To: **Fiona Thomson: N6/2013/1938/MA Council Office Extension**

I wish to register my objection to the above planning application on the following grounds:

Title Proposed Materials

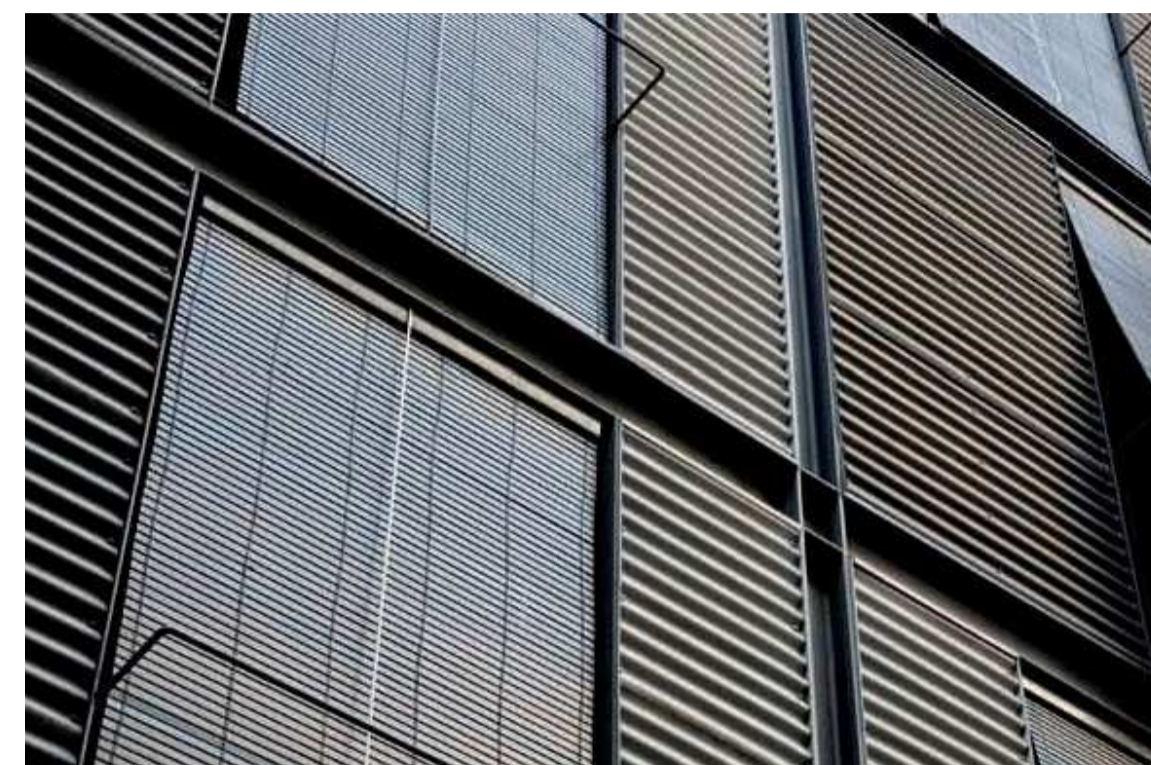
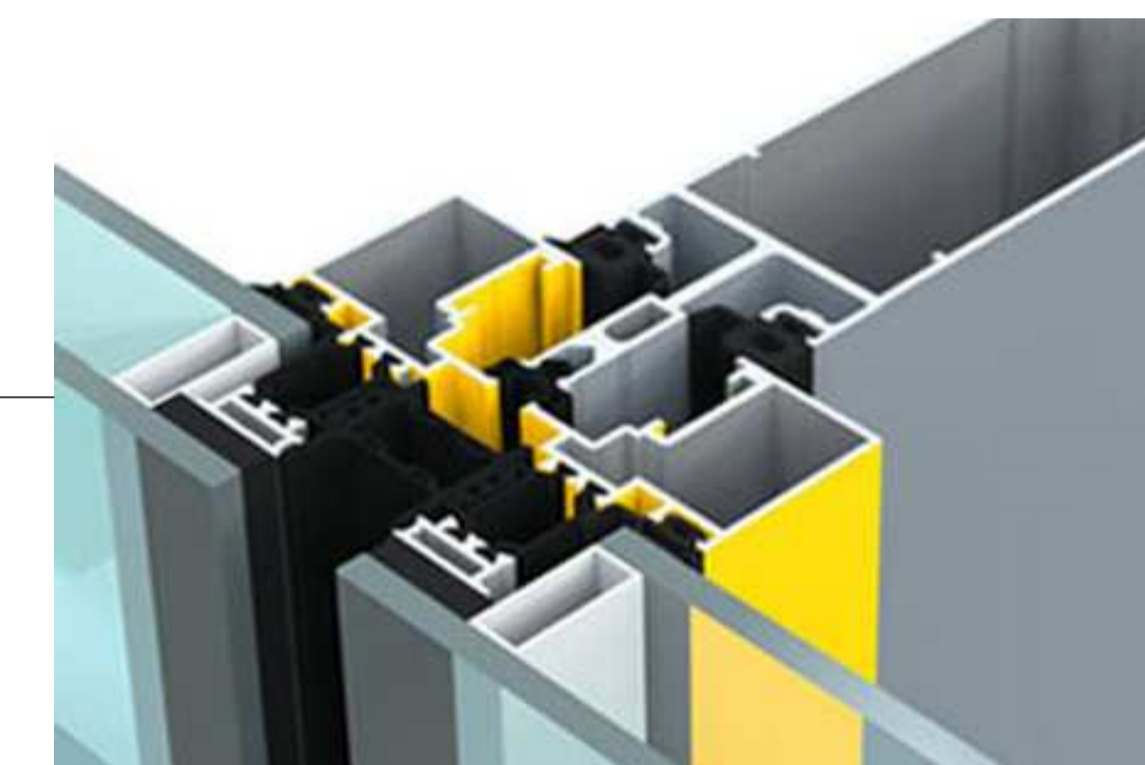
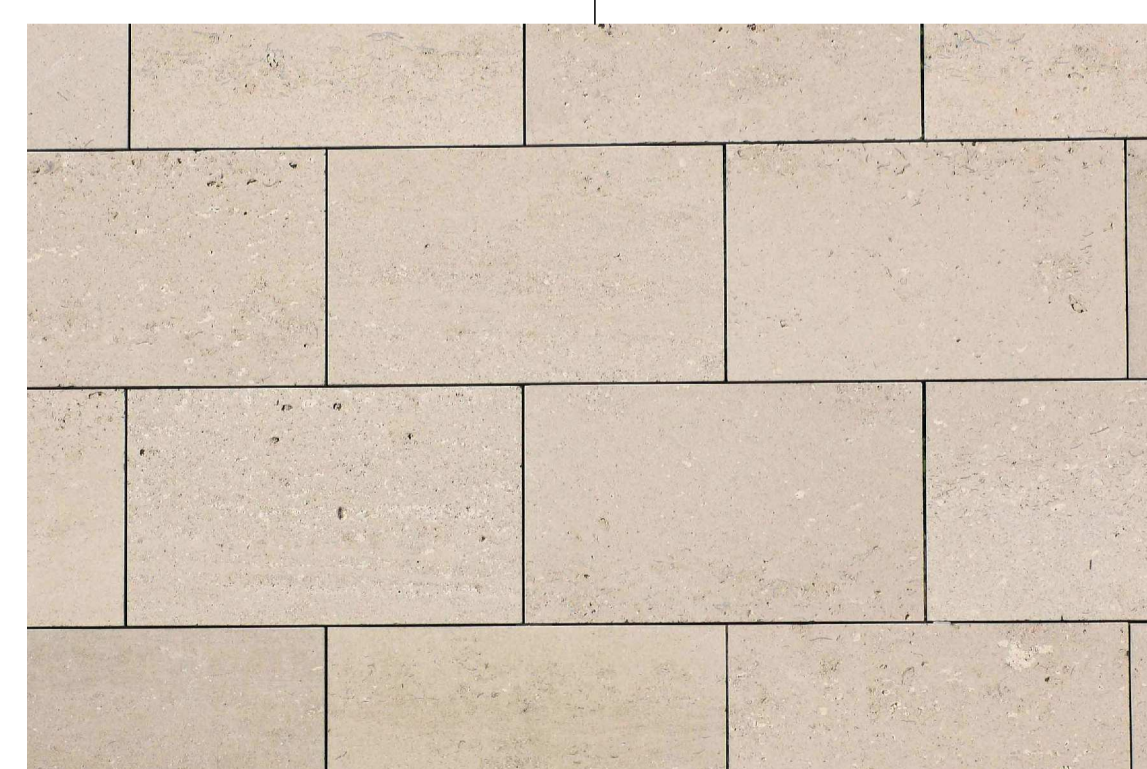
2. The proposed design, its materials and proportions, are both inappropriate for such an extension which is a rear entrance to an existing building.
3. The internal layout appears to fail Building and other regulations for office space and sustainability requirements. The proposed design of the Council chamber restricts its use for public meetings.
